Project Title: Water Lane, Angmering

Project No/ Document Reference: A290-TN007

DRAINAGE – CONDITIONS DISCHARGE

Scale AS SHOWN@A1	Date DEC 20	Drawn DS	Checked SM
Drawing No A290-612			CIV-1-4062 A Revision A

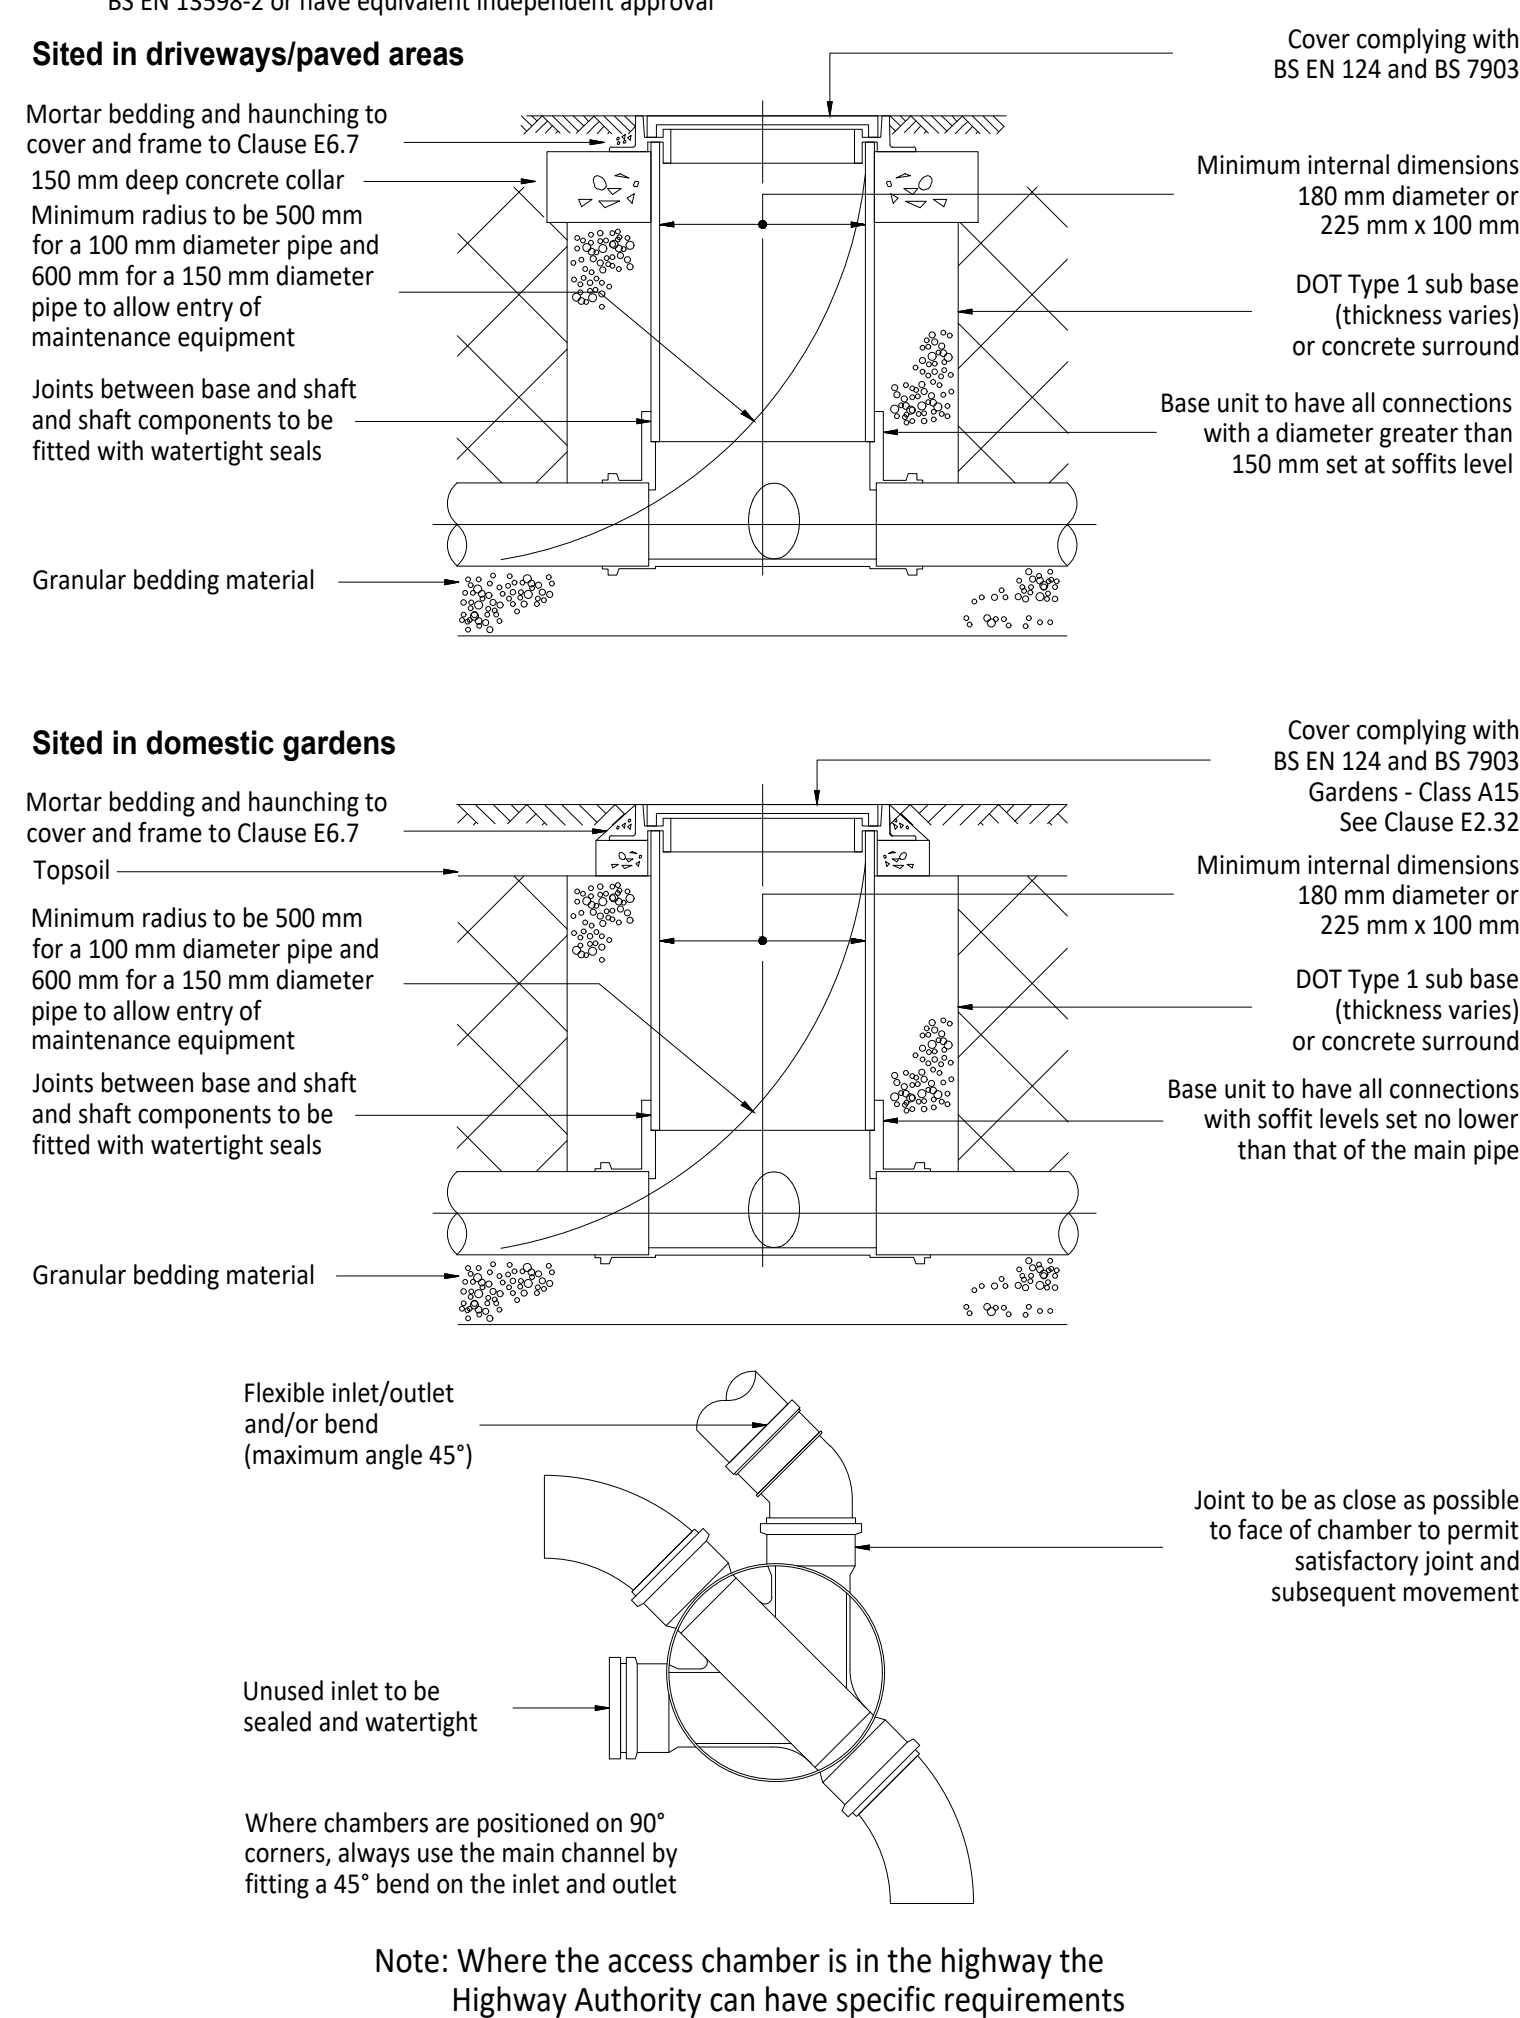
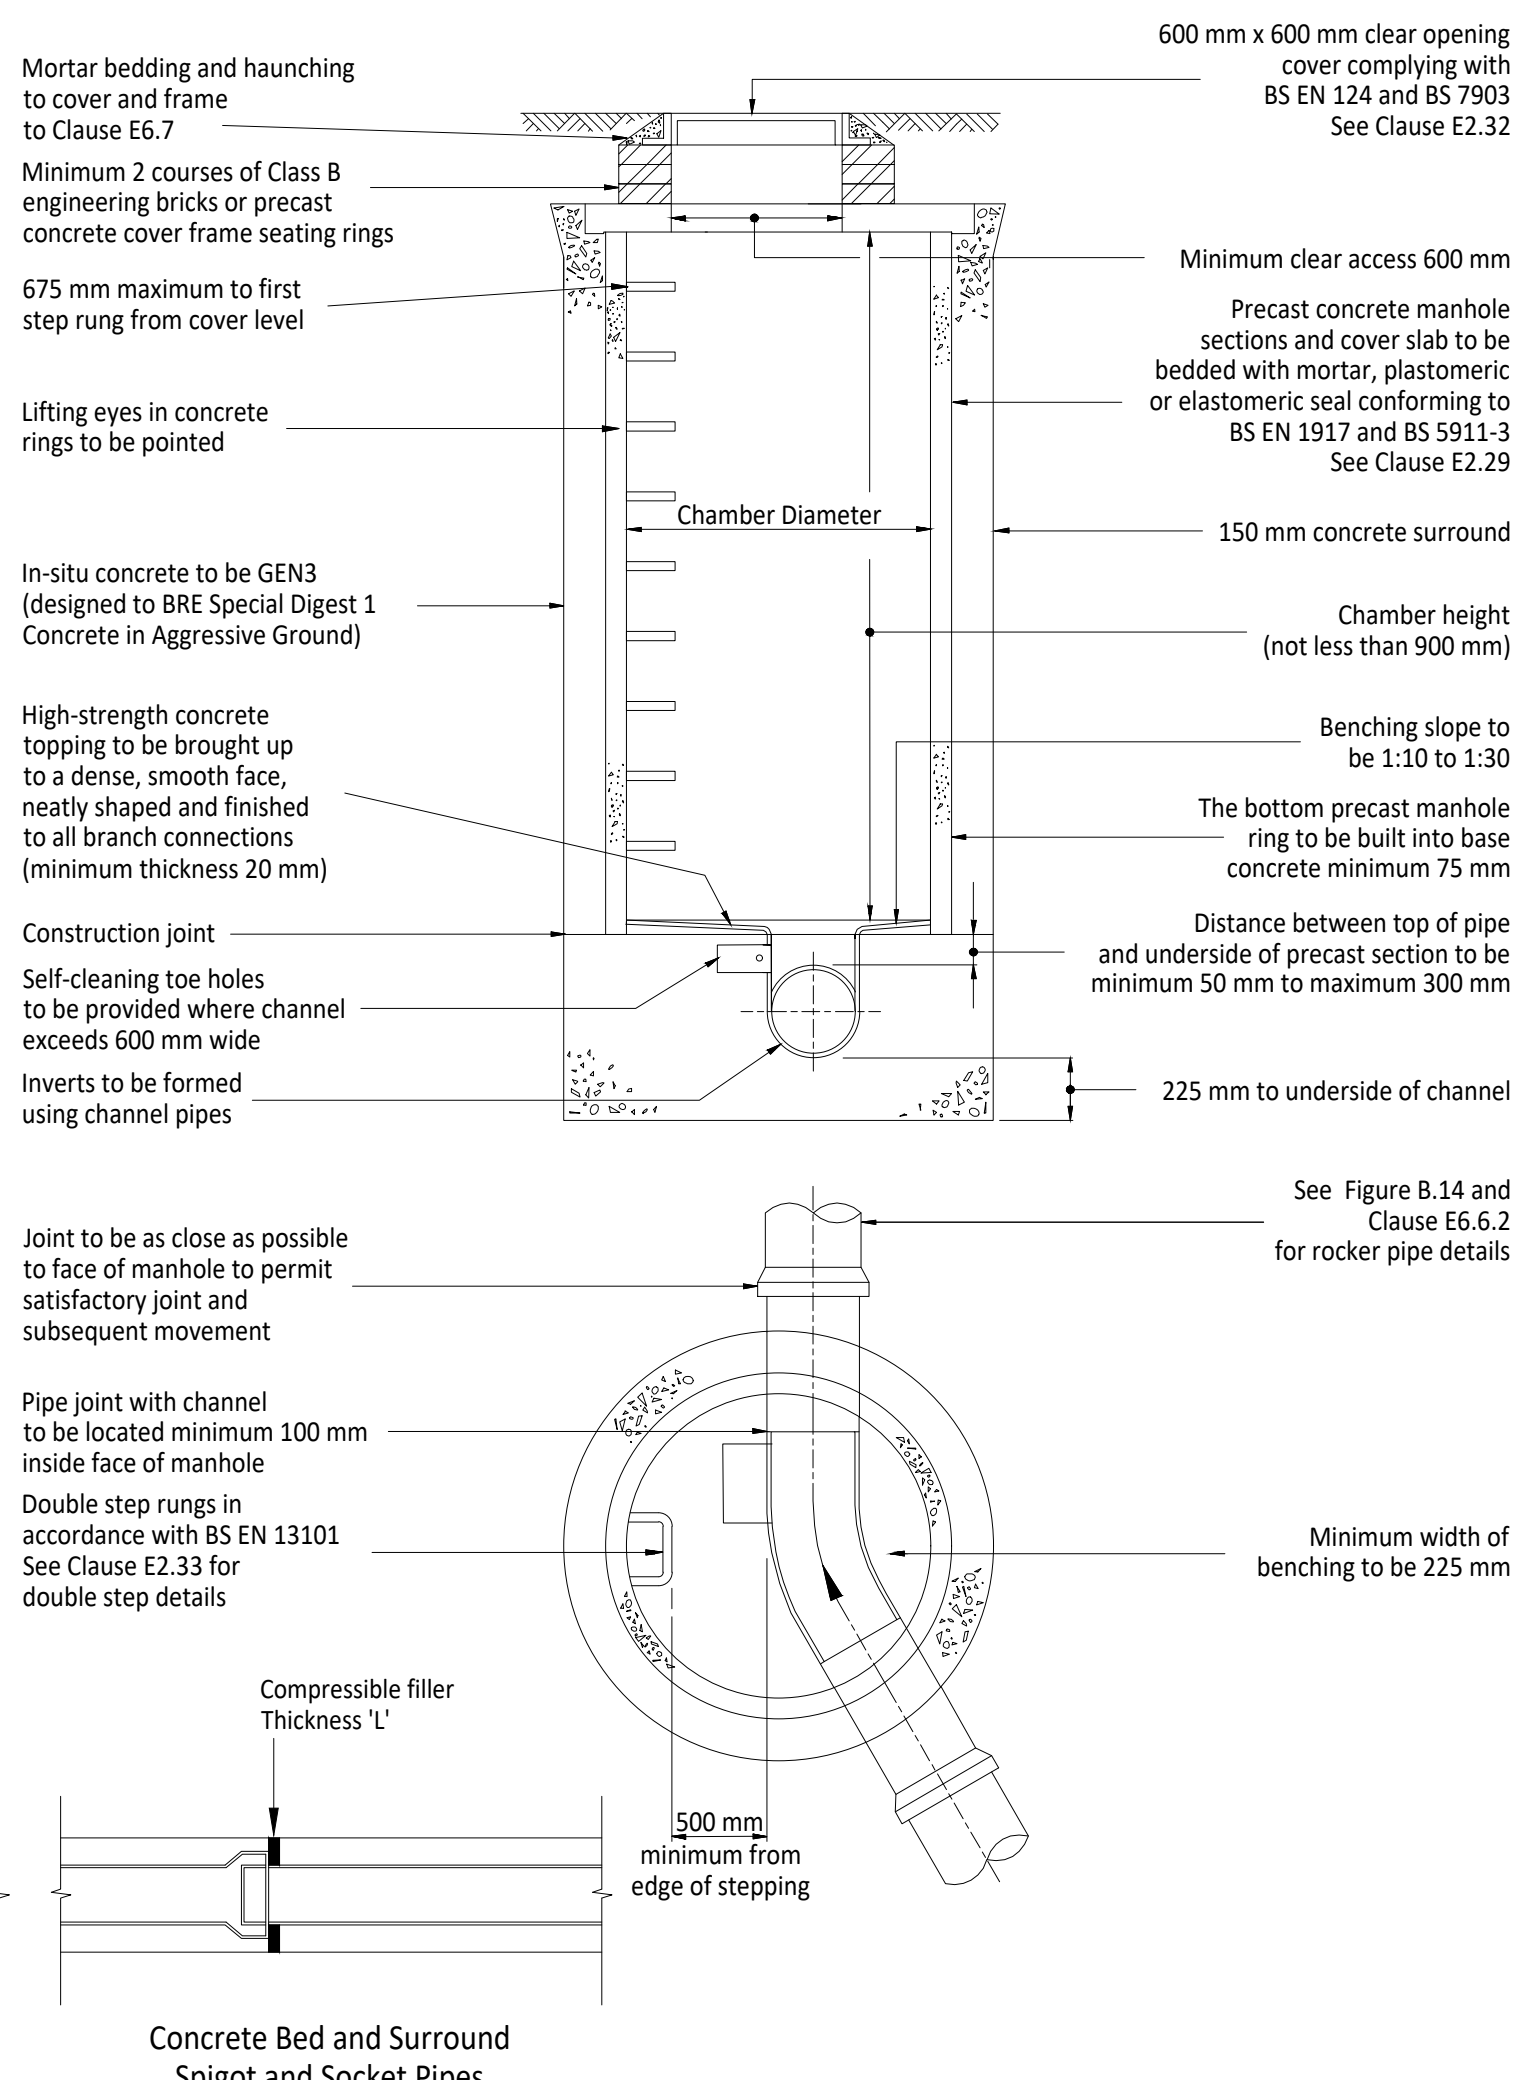
21. *Construction details are required of the proposed headwall to watercourse, channel drains, catchpits, gulleys.*

22. *The hydrobrake construction detail drawings should be site specific and show invert level, cover level, and incoming and outgoing pipe diameters. Hydrobrake unit reference and invert level is different between calculations and detail. Detail shows the hydrobrake set in a weir wall, the hydrobrake invert plus design head gives a level of 13.2mAOD, it is unclear how you are going to achieve 100mm free clearance between the top of weir wall and base of slab when you have a cover level of 13.50mAOD, require a minimum of two courses of engineering bricks and cover slab depth is 250mm. There clearly isn't enough space. Consider removing weir wall. If weir wall is retained we will need to see that the weir level is above the 1 in 100 year plus cc event water level and that it is physically possible to build.*

This has been noted and included on the drawings.

This has been noted and included on the drawings. The weir wall has been removed with a further manhole downstream for inspection and maintenance.
